**Consultation Response from KC,  
Lead Local Flood Authority**

**2025/93435 Land off, Blackmoorfoot Road and Felks Stile Road, Crosland Moor, Huddersfield, HD4 7AD**

**Discharge of details reserved by conditions 16 (retaining walls), 17 (structures in HW), 18 (drainage strategy) on THE WESTERN PARCEL OF previous permission 2024/92614 for variation and removal of conditions 4 (access works), 8 (Blackmoorfoot Road improvements), 10 (junction details), 16 (retaining wall design), 17 (highway structure design), 18 (surface water drainage strategy), 37 (external lighting strategy), 39 (crime mitigation measures) on previous outline permission 2020/92546 (with details of points of access only) for the development of up to 770 residential dwellings (Use Class C3), including up to 70 care apartments (Use Classes C2/C3) with doctors surgery of up to 350 sqm (Use Class D1); up to 500 sqm of Use Class A1/A2/A3/A4/A5/D1 floorspace (dual use), vehicular and pedestrian access points off Blackmoorfoot Road and Felks Stile Road and associated works**

**Date Responded: 16<sup>th</sup> January 2026**

Project: **Blackmoorfoot, Huddersfield**  
 Title: **S104 BMF - Impermeable Area Plan**

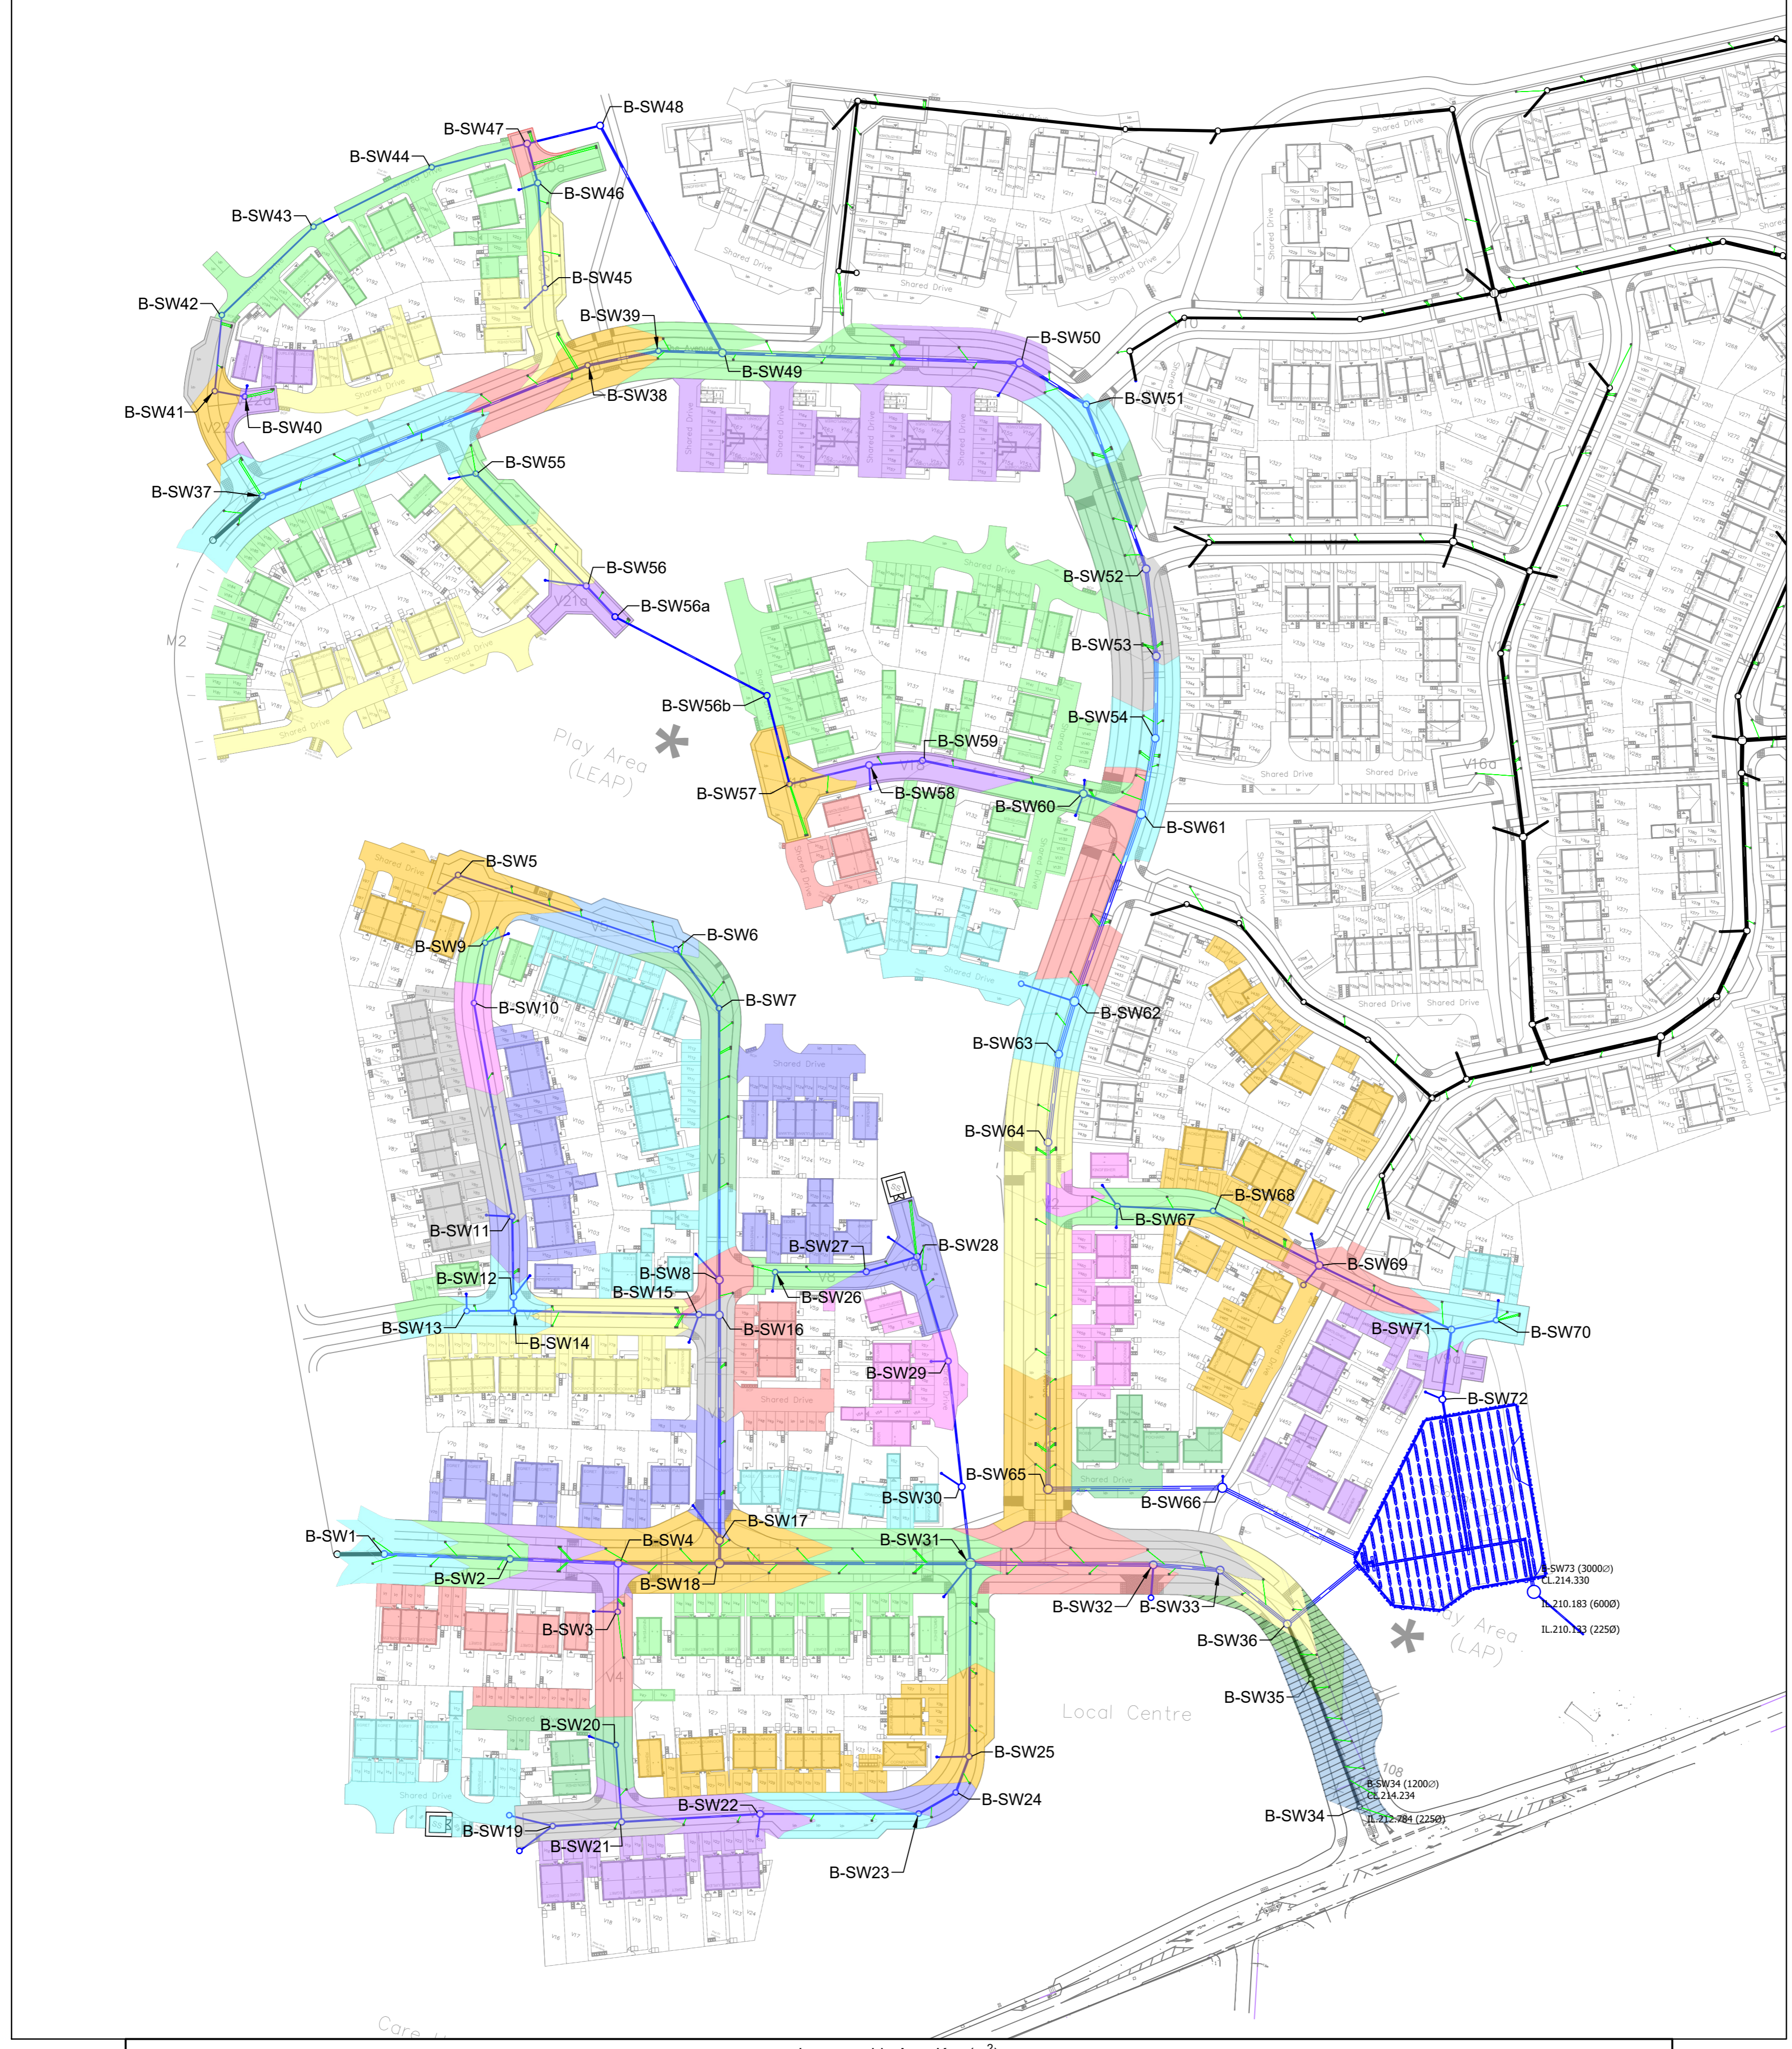
There are two types of coloured hardstanding drawings showing contributing areas to surface water runoff. These plans should be coloured according to which leg of sewer they are contributing to. Some plans do not show household connections, only gullies. Plans showing gullies are to be rejected as it can clearly be identified with multiple examples areas of road with gullies connected between two given manholes are different colours.

All such drawings should be meticulously reviewed and resubmitted. Clear evidence of private drainage to a lateral drain prior to connection to a main run should be submitted.

Revised drawings should state the leg number for hydraulic simulation between manholes, e.g. 1.001, 5.003.

Fully calculated drained areas should be shown on these drawings.
